### **Widefield PK-8 School, PPR-18-026**

Please accept the following comments from El Paso County Public Health (EPCPH) regarding the project referenced above:

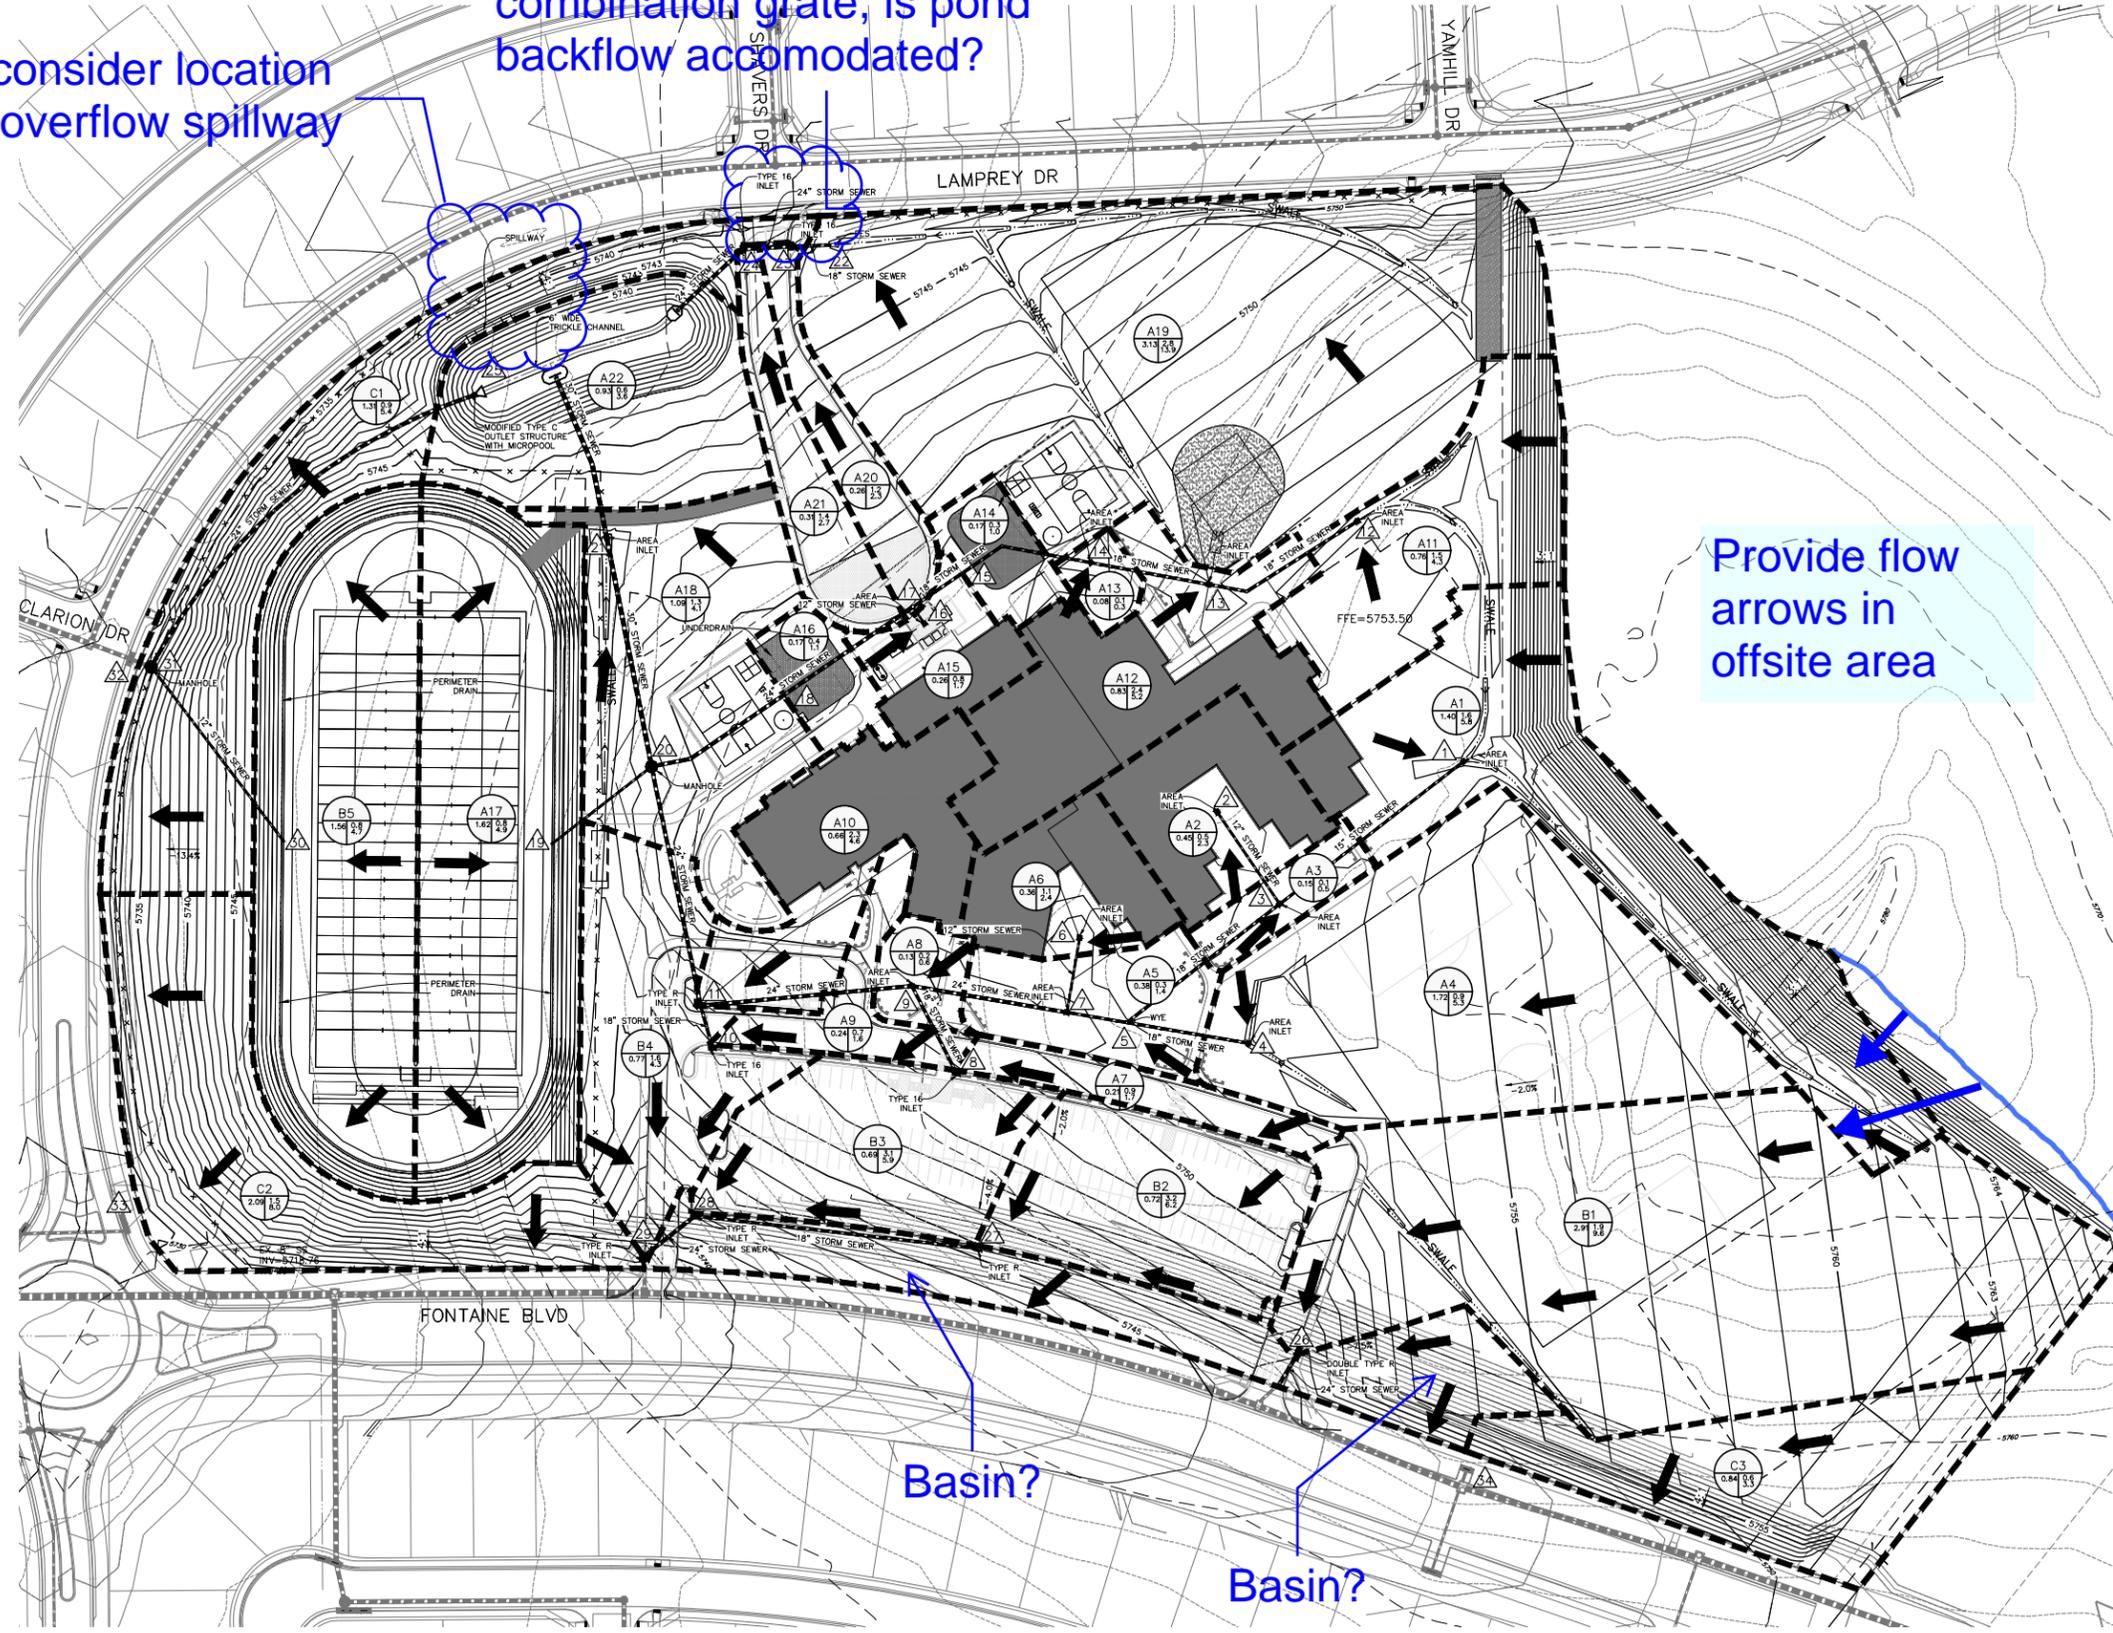
- The proposed detention pond must be included in a maintenance plan for mosquito control measures and the protection of public health from mosquito borne diseases.
